#### Thurrock Flexible Generation Plant

Application document number A5.1.8

**THURROCK FLEXIBLE GENERATION POWER PLANT IN THURROCK - REVIEW OF HYDRODYNAMIC MODELLING.**

**LAND TO THE NORTH OF FORMER TILBURY POWER STATION**

Figure 2.8: Local flow speeds during peak flood (top) and peak ebb (bottom). Black box indicates the site.

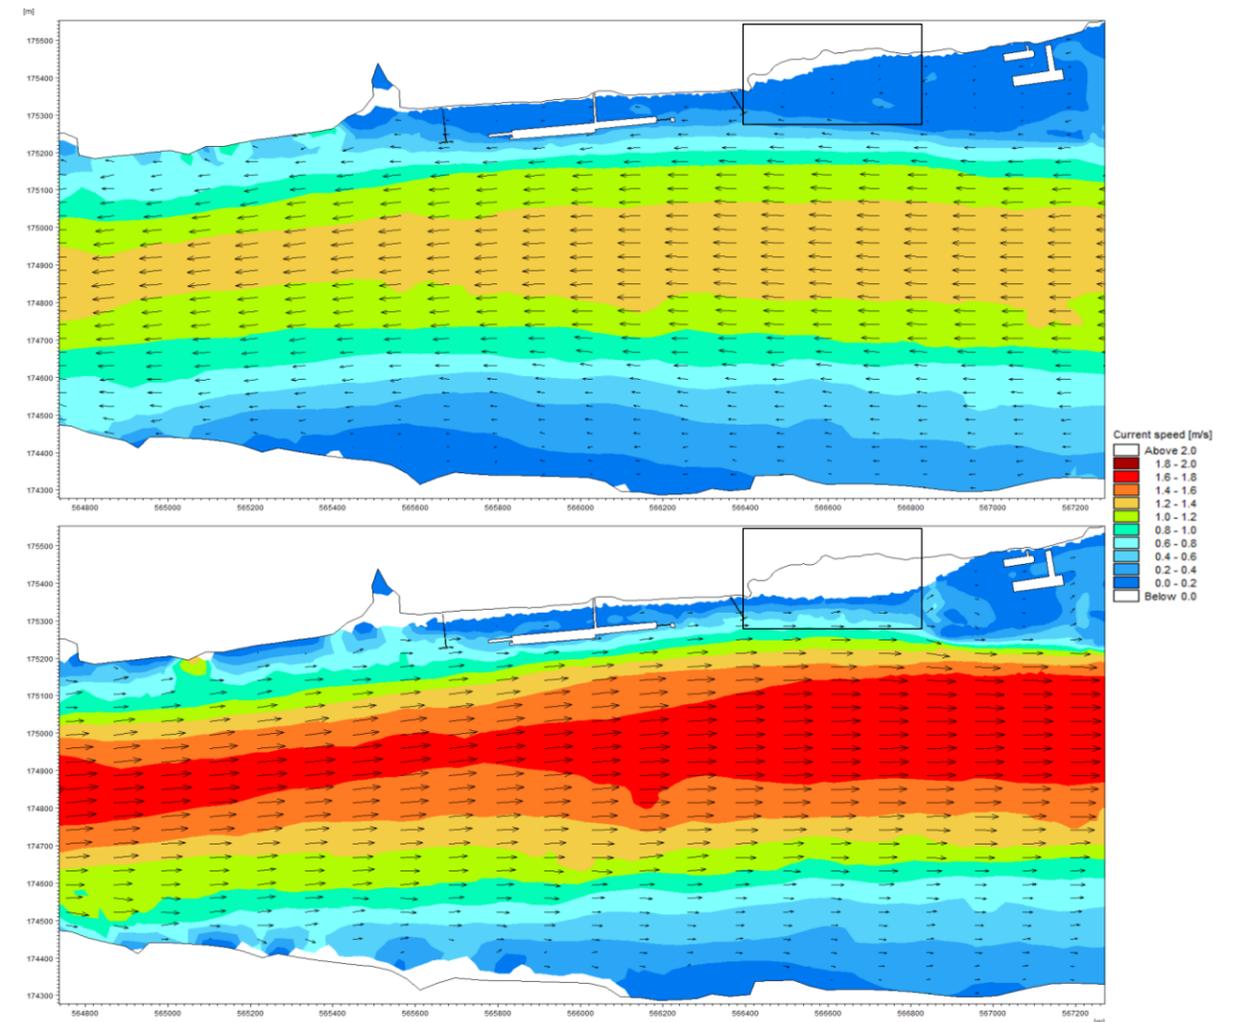
\* Peak flood and ebb conditions need to be specified: this ideally needs to be during the Highest Astronomical Tide/a storm surge when currents are at their fastest.
